**COLORADO**  
Department of Transportation  
Region 2

February 28, 2019

RE: Meadowlake Ranch Sketch Plan\_EA17227\_SKP184

SKETCH PLAN

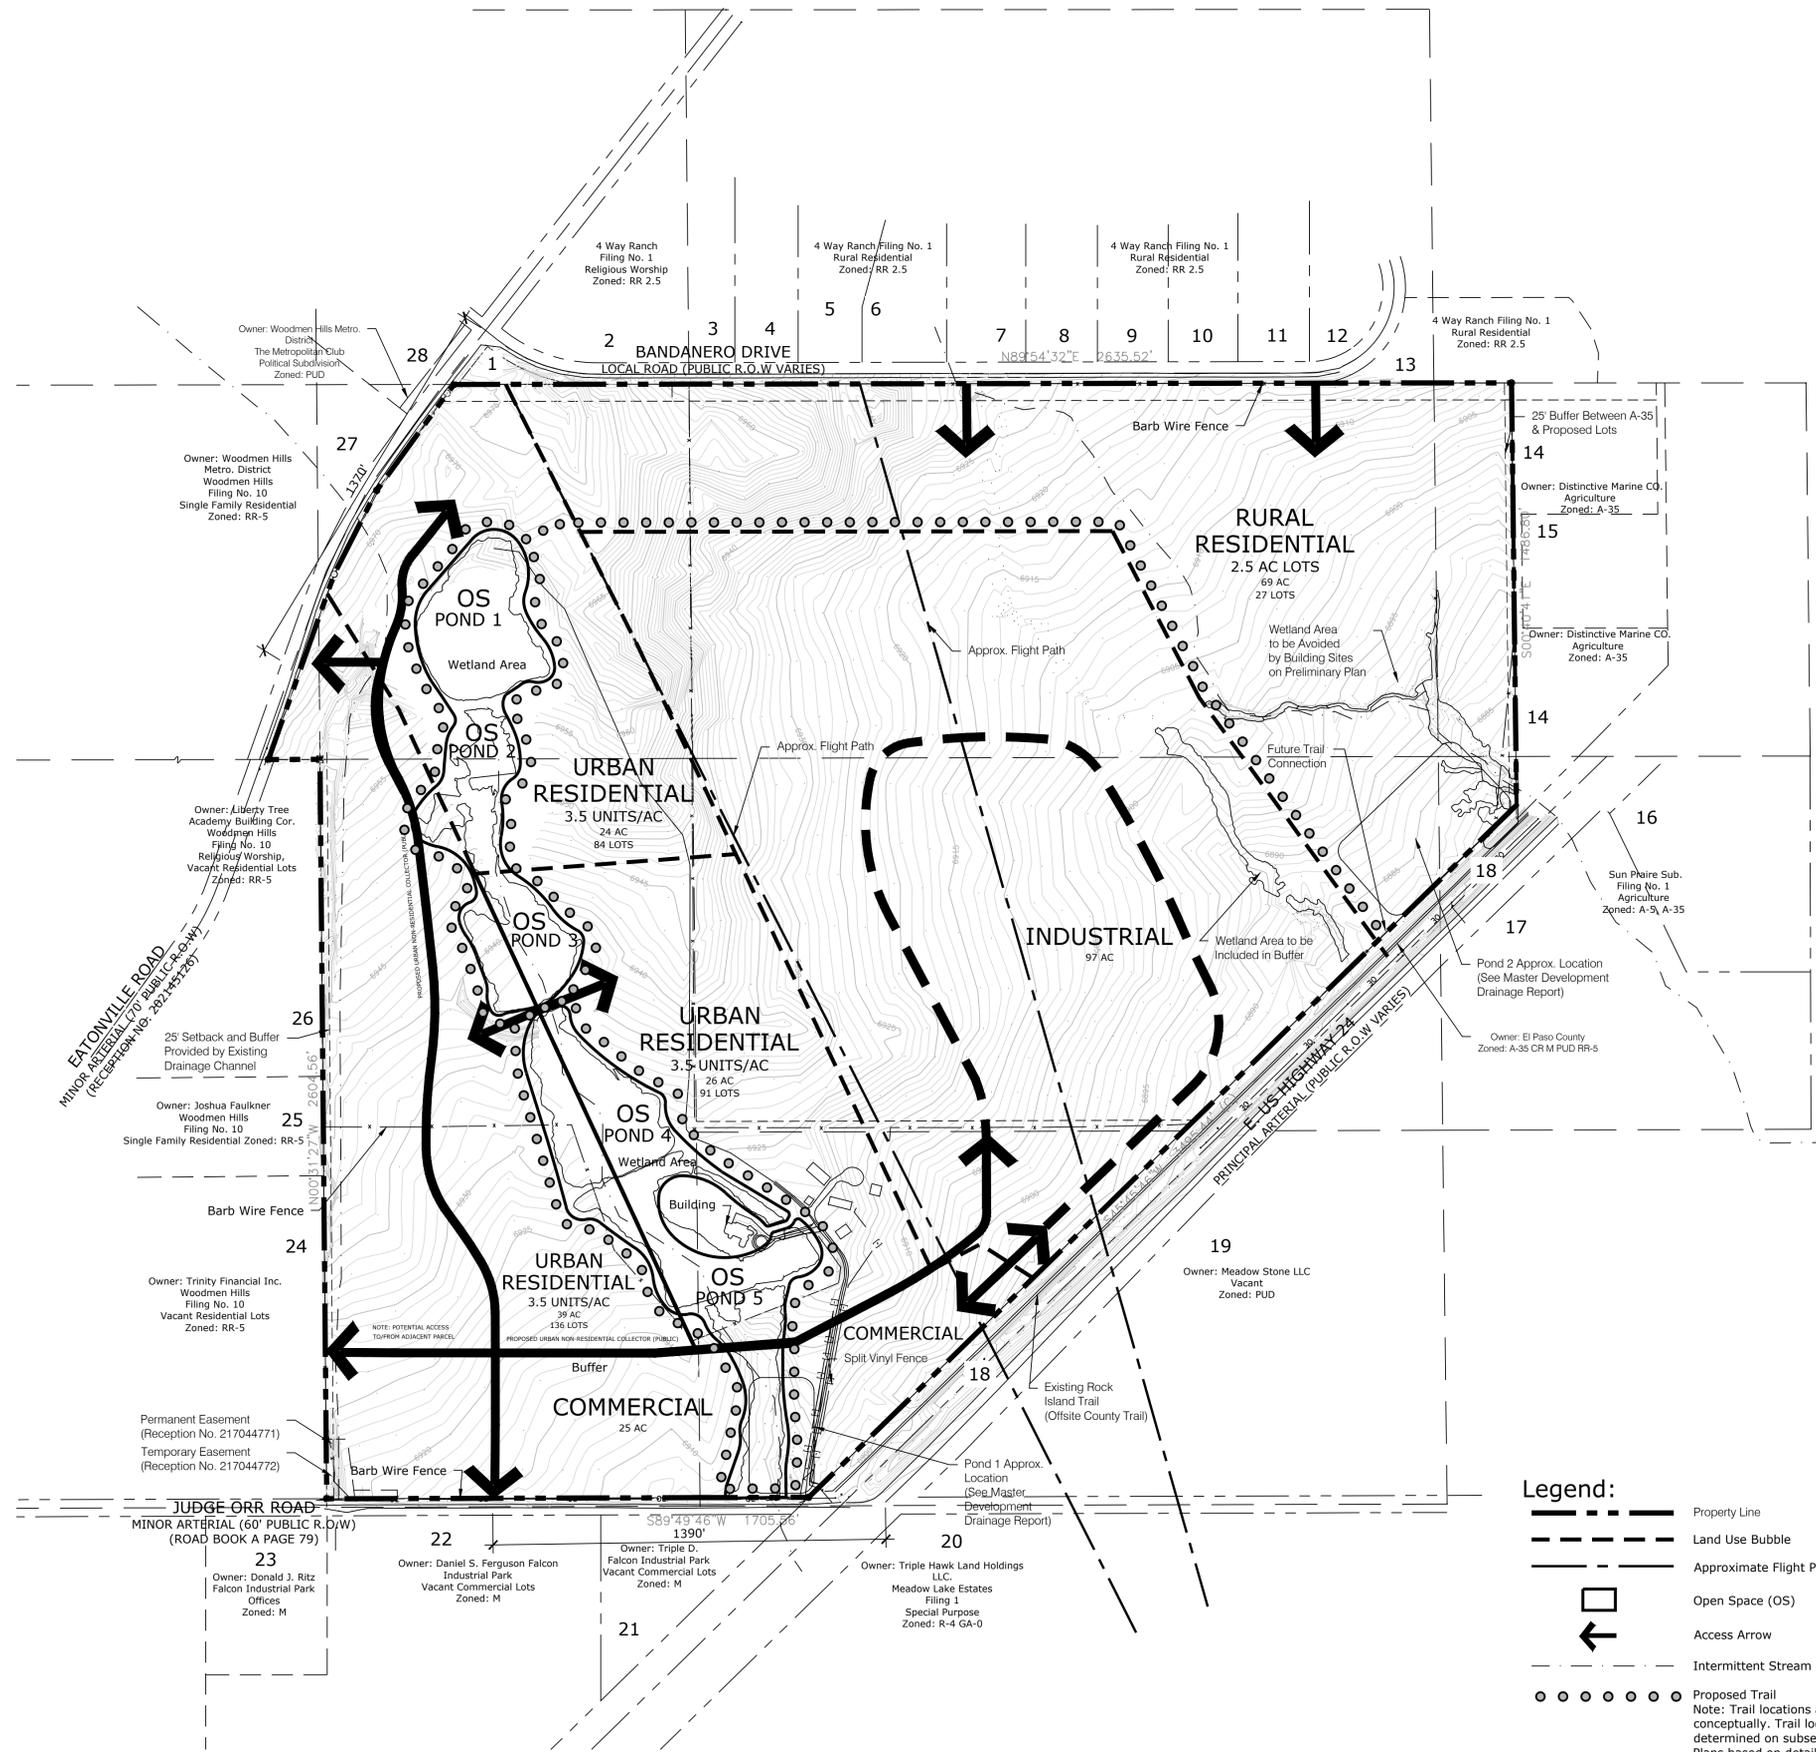
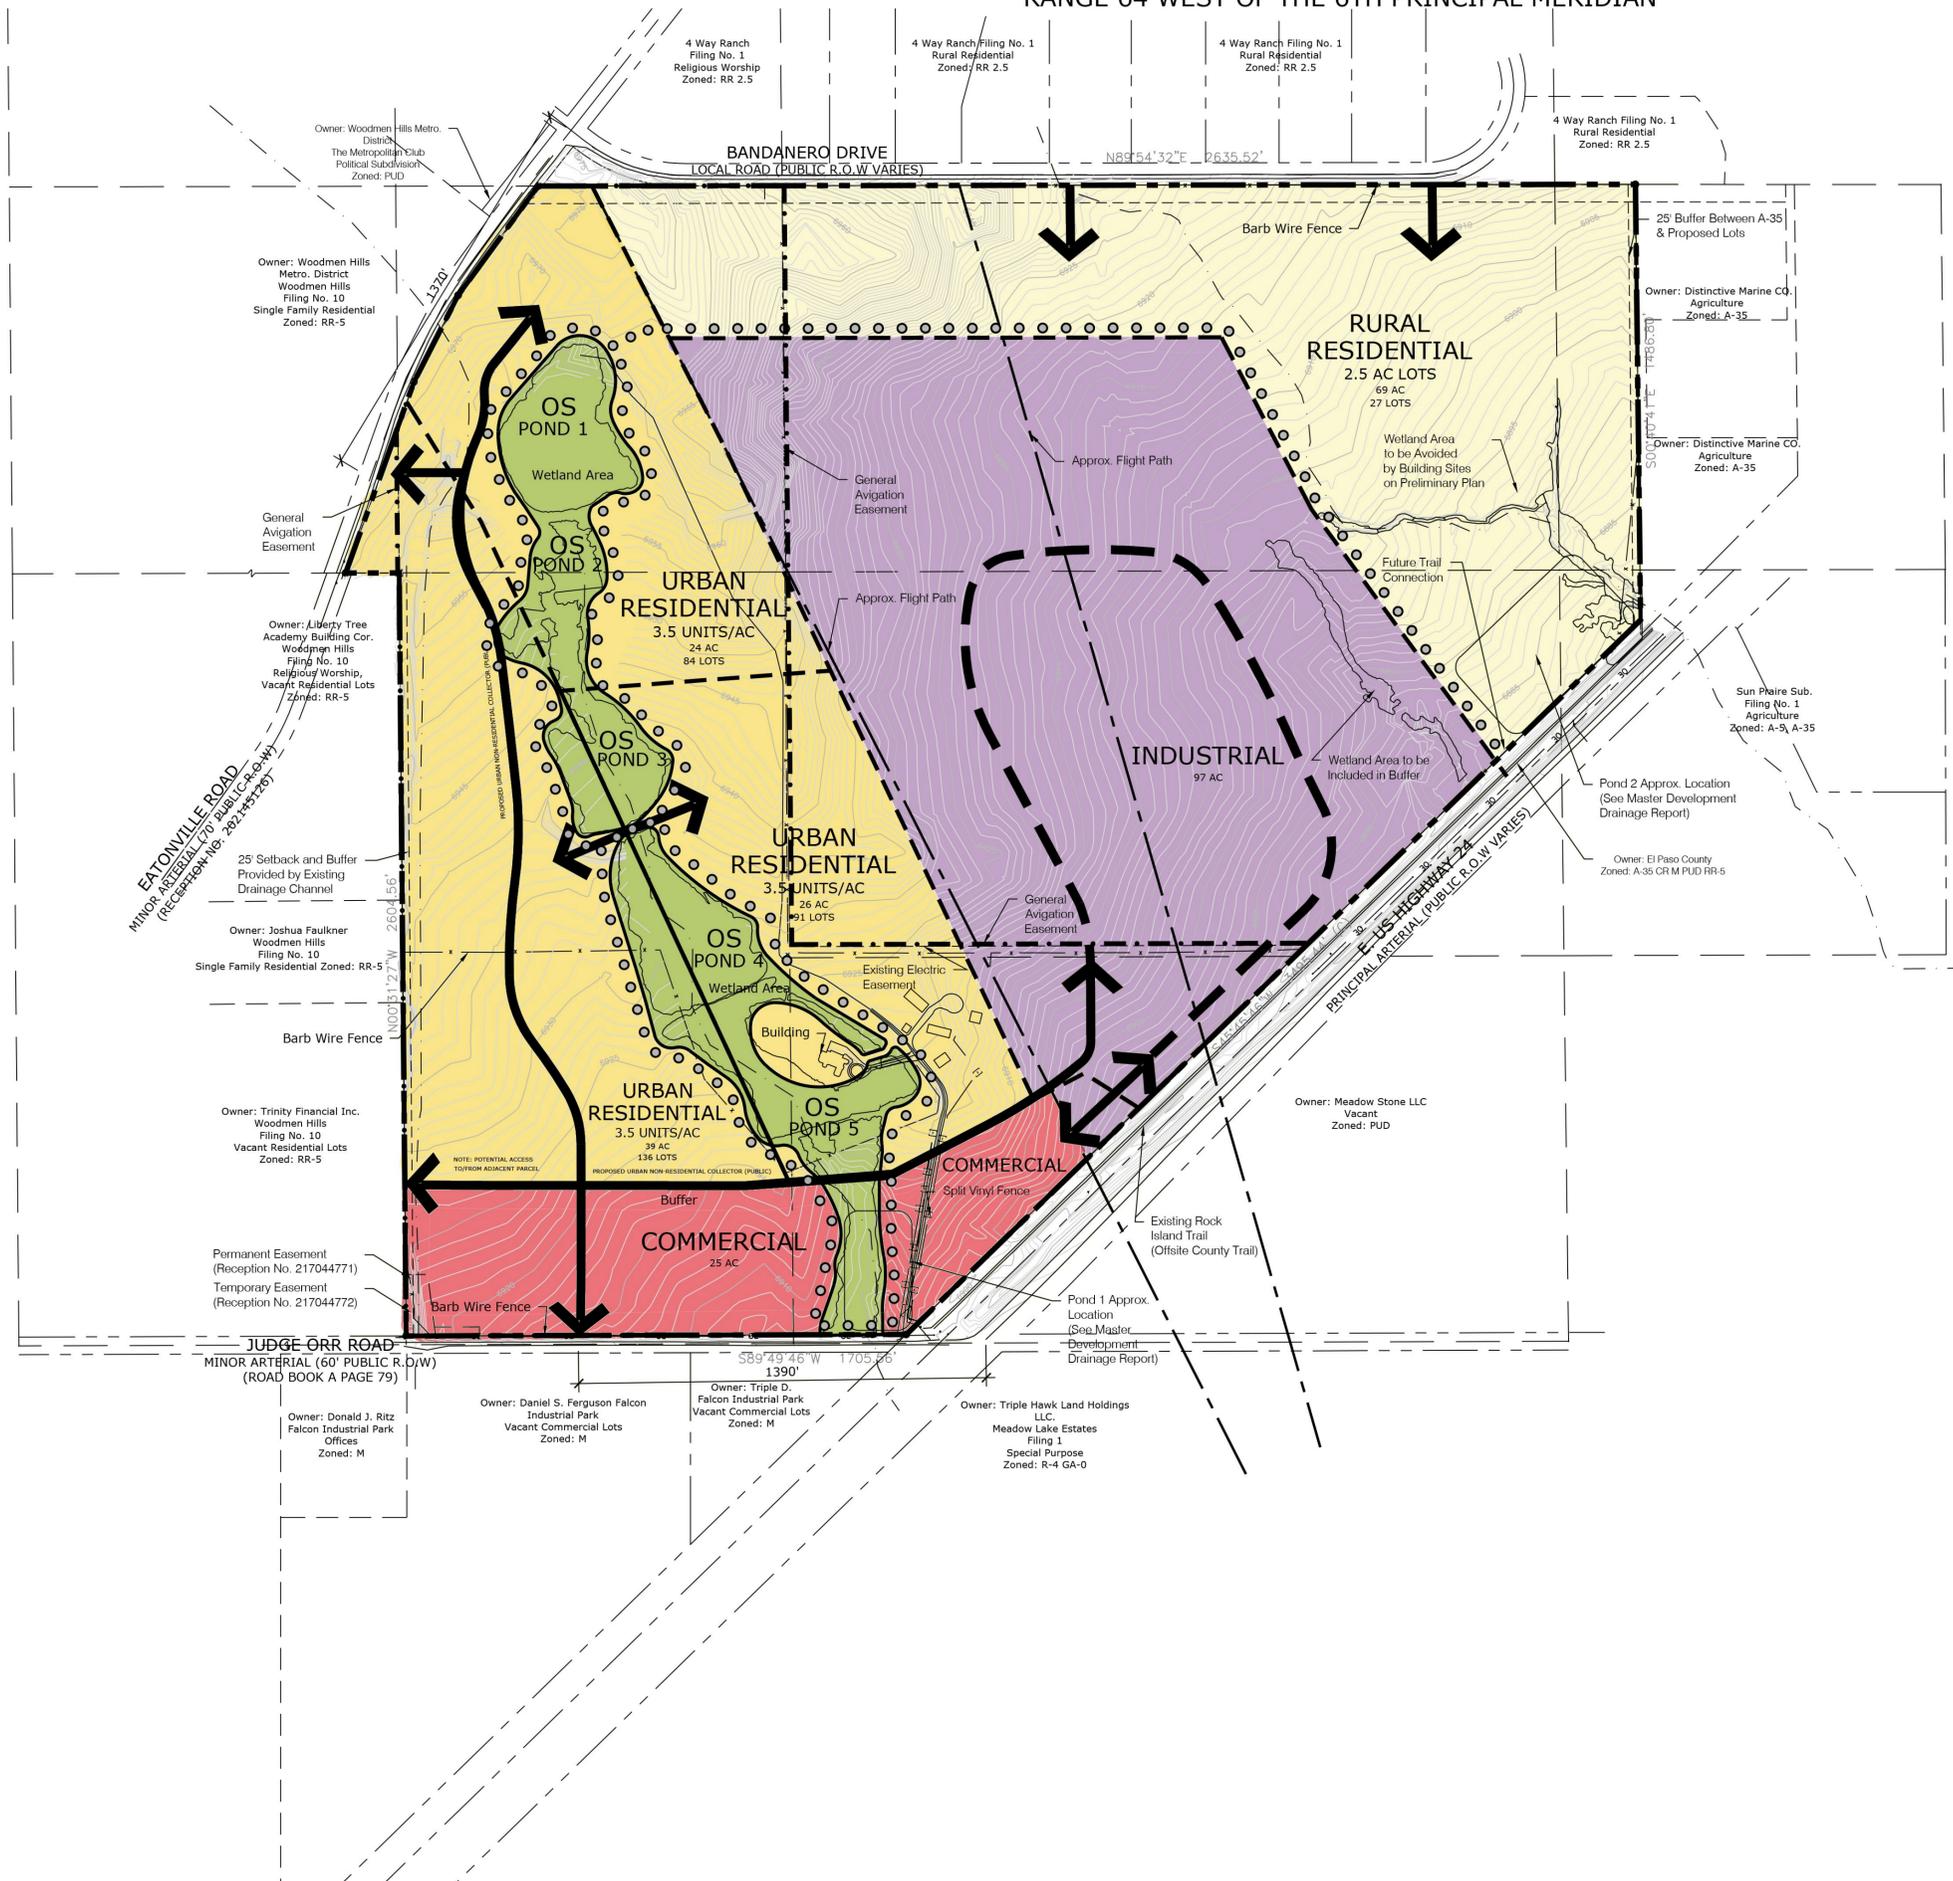
- b. Since US 24 is not being realigned, the developer will be required to construct the southwest-bound right turn deceleration lane along US 24 and Judge Orr Rd.

- c. Since US 24 is not being realigned, the developer will be required to construct the southwest-bound right turn acceleration lane along US 24 and Judge Orr Rd.

- d. The developer will be required to construct eastbound right turn deceleration lane on Judge Orr Road approaching US 24 to allow traffic to bypass thru/left traffic queue at the traffic signal.

- e. The southeast corner of the site should be preserved for the future re-alignment of Judge Orr Rd.

- d. Let it be known that the signalized intersection at SH24 and Judge Orr Rd. will be reconstructed at some time in the future and may impact the development. Re-Alignment of the intersection at SH24/Judge Orr Rd is to provide an intersection angle of 90° and will impact the development.
- e. Escrow funds should be collected for the future improvements to the intersection(s) of SH24/Judge Orr, SH24/Stapleton or the development will need to incur the costs for improvements.
- f. Intersection access will not be allowed for up to 550-feet from the intersection per the Colorado State Access Code.
- g. CDOT requests the opportunity to review the required intersection plans.
